From: Ewan Stewart
Sent: 27 April 2022 09:01
To: James Kirkham
Subject: RE: 21/02180/REM - Fritwell - Reserved Matters

I have checked the revised details against the comments which Frances submitted, and would make the following further comments regarding the accommodation schedule:

Plots 09, 10, 18, 19, 25 & 26
Floor Plans and Elevations

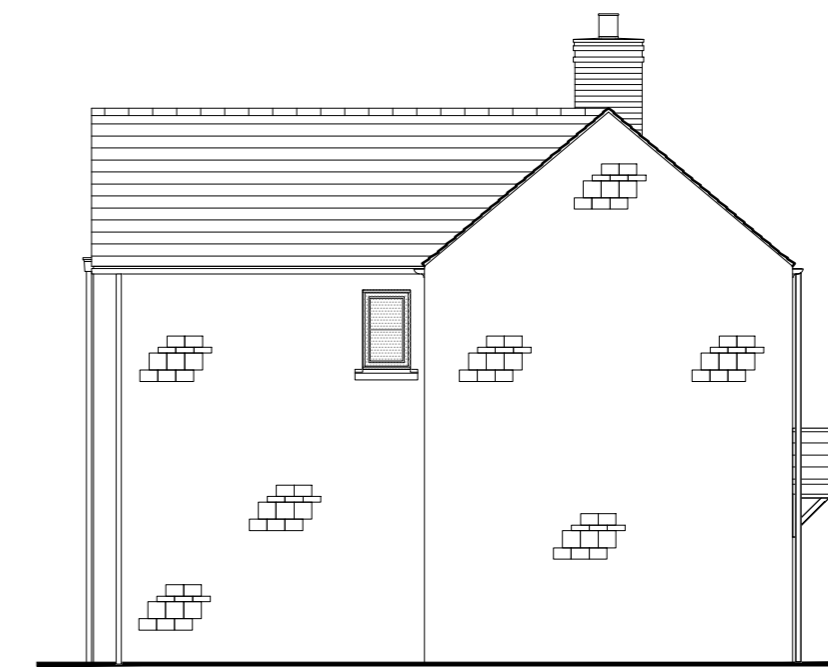
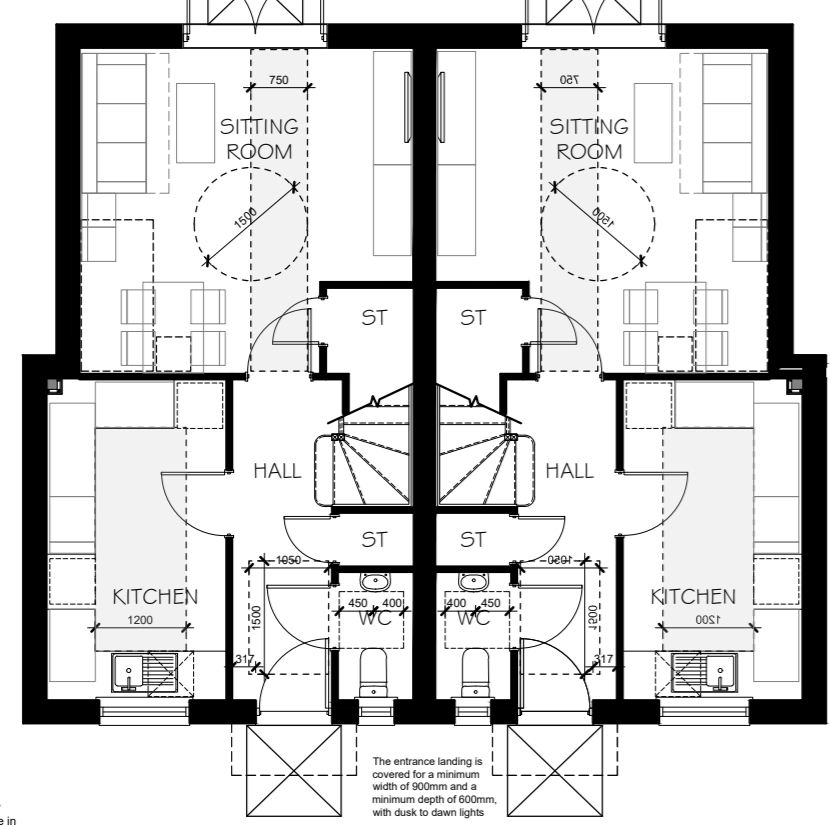
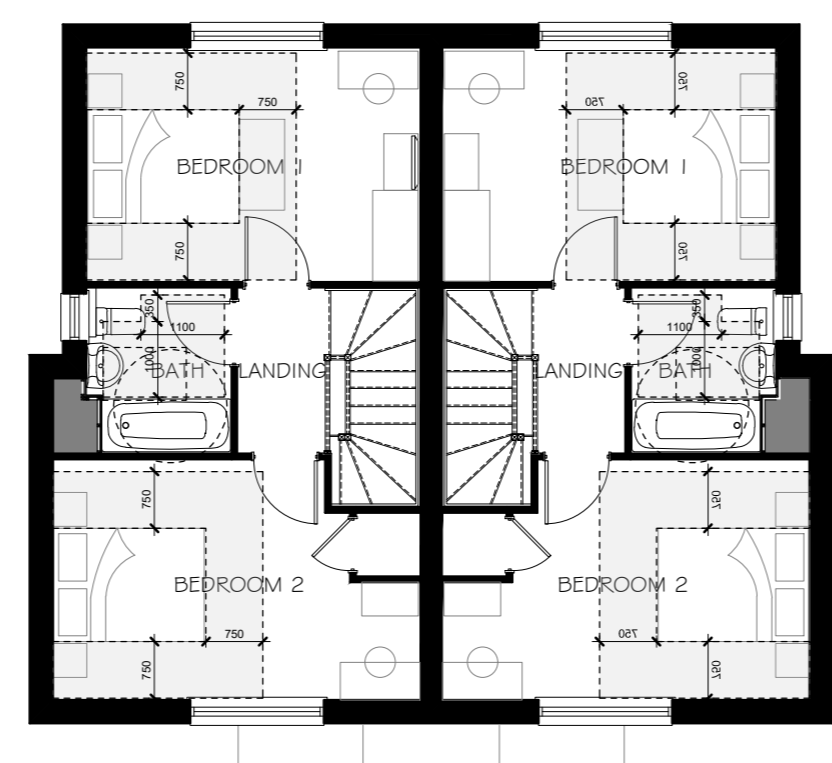
1. The proposed types and sizes of affordable dwellings are acceptable and accord with the requirements Frances set out in her comments
2. Confirmation of the tenure mix is still required, the tenure plan refers simply to "affordable units". On this development the requirement is for 7 social rented and 3 intermediate.

3. I would suggest that the intermediate dwellings consist of 2no. 2-bed 4-person and 1no. 3-bed 5 person dwellings.
4. We require confirmation that the dwellings sizes will be 1-bed 2-person, 2-bed 4-person and 3-bed 5-person

5. We welcome the confirmation that all affordable dwellings will meet NDSS requirements. We require this to be made clearer on the plans, as it has not been confirmed that the larger sizes are being provided as set out in point 4. We require the plans to state the exact dwelling size and GIA.
